M/42/17/44

Re planning application M/42/17/HN re 14B Sea Way Middleton on Sea

GROUND FLOOR

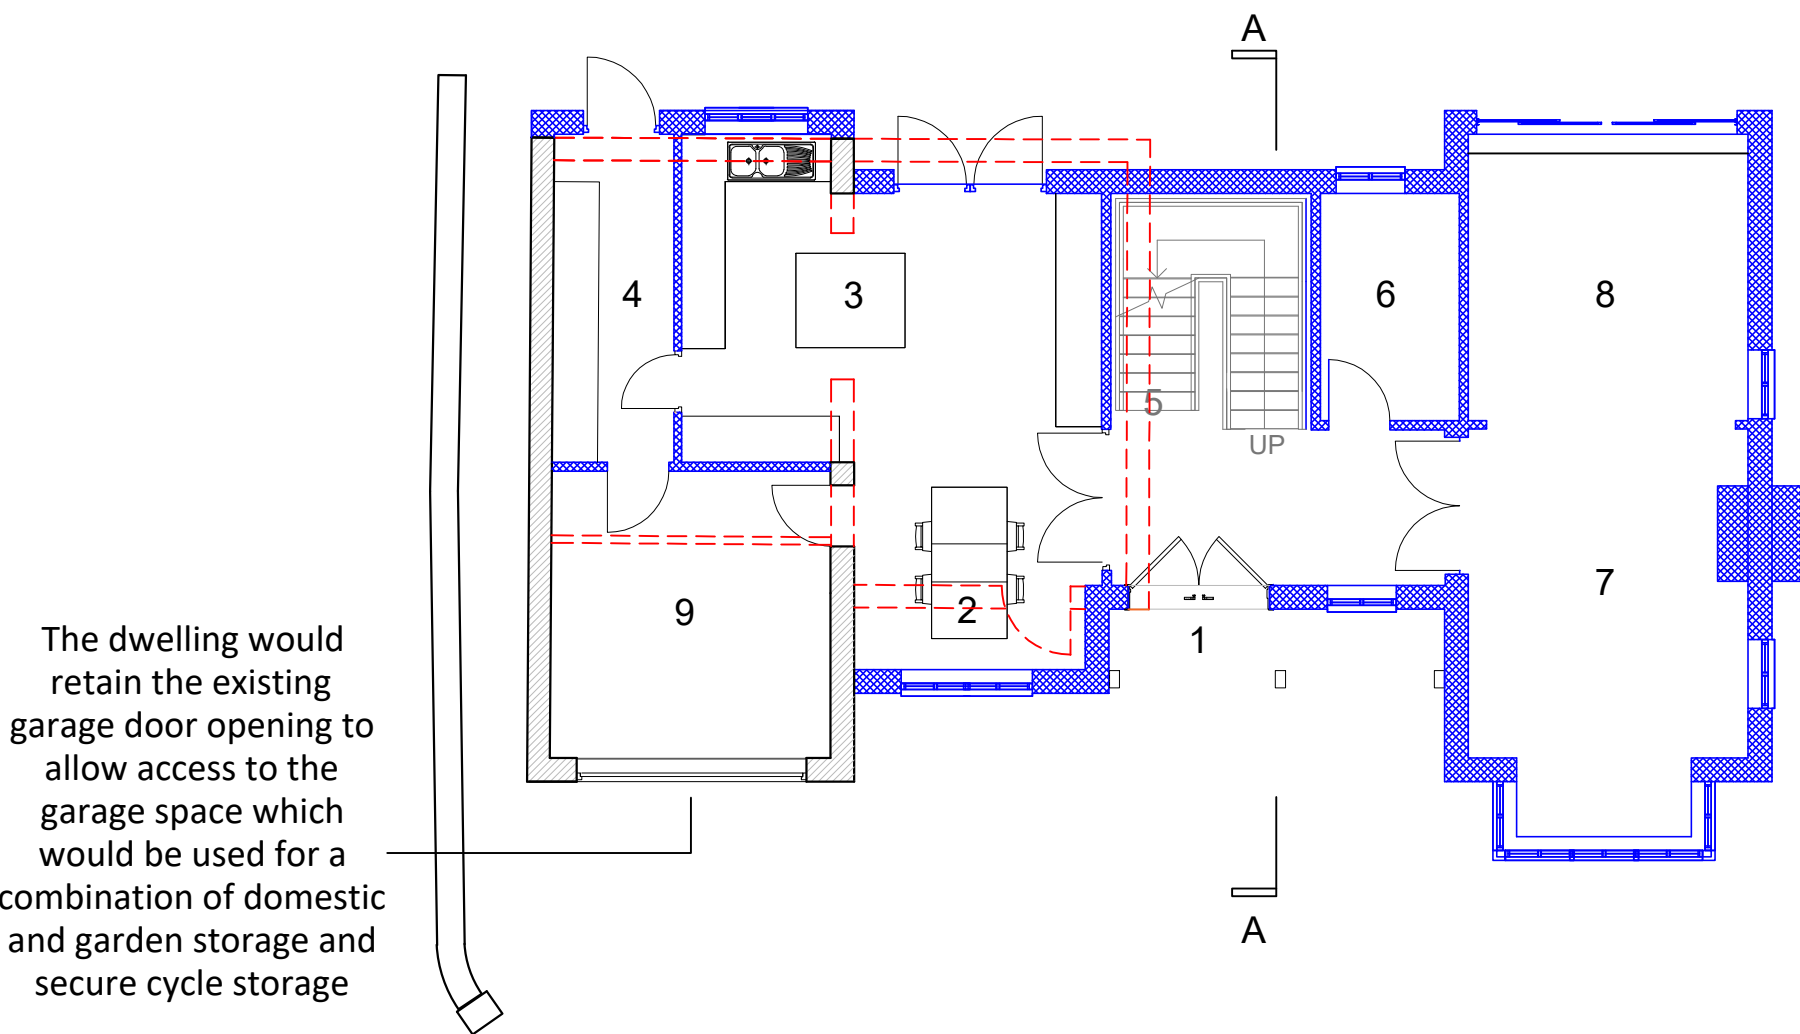
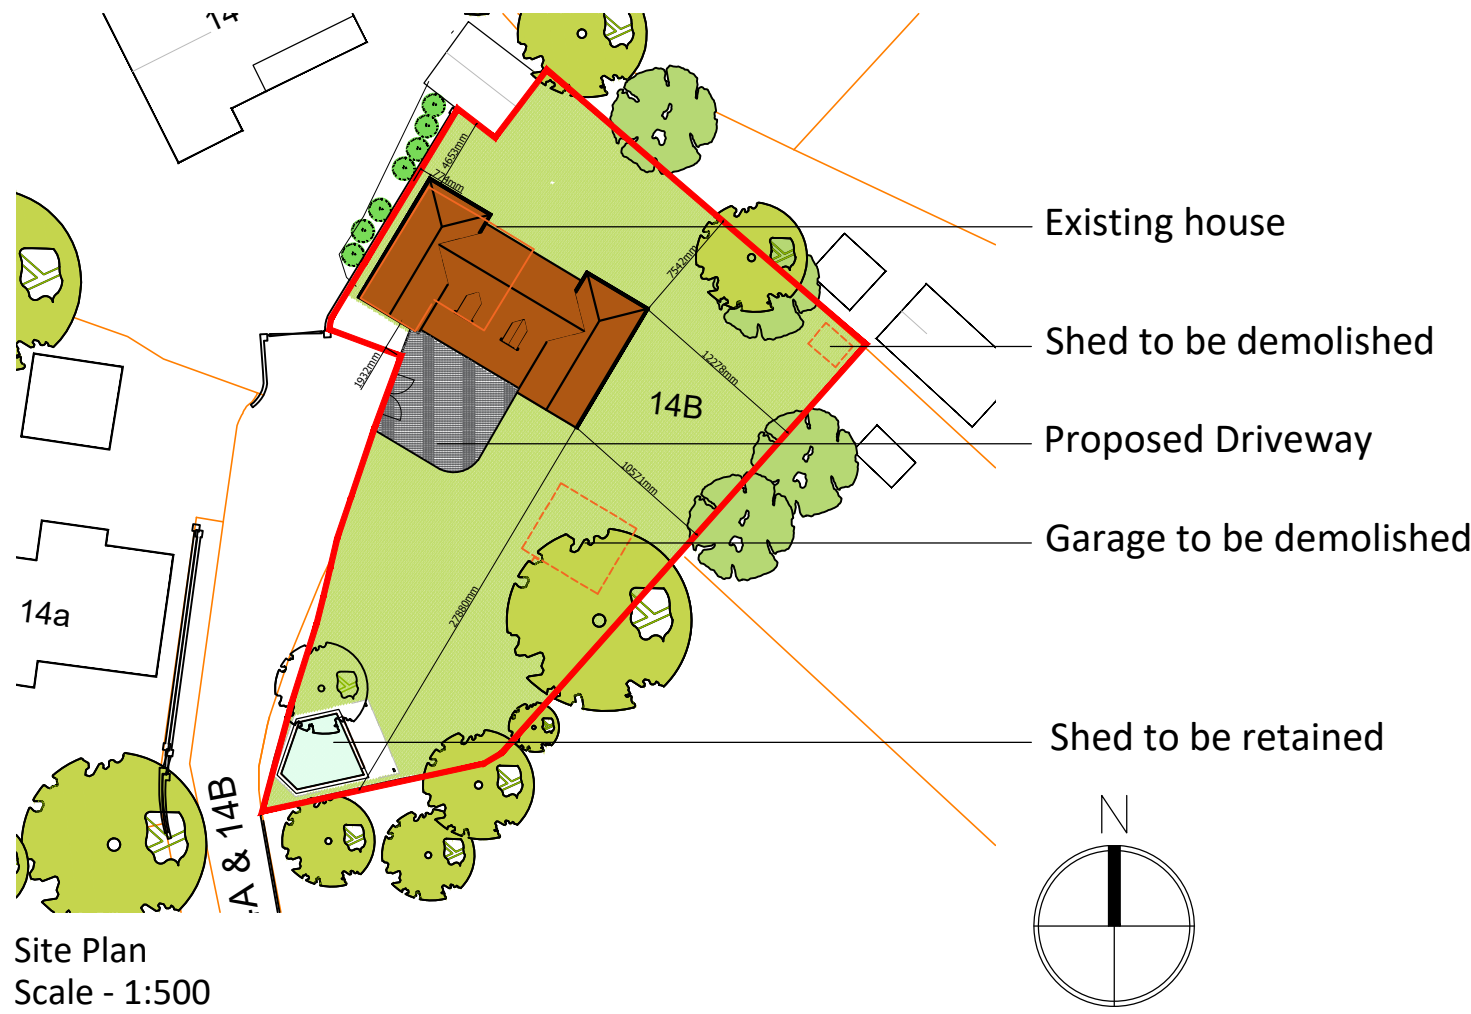
The matter of parking seems strangely dealt with. The existing residence appears to have an integral garage possibly adjusted to become part of the house. There appears to be a "garage" in the garden with no visible vehicular access. That seems to encourage street parking which is discouraged by MOSA and the estates residents.
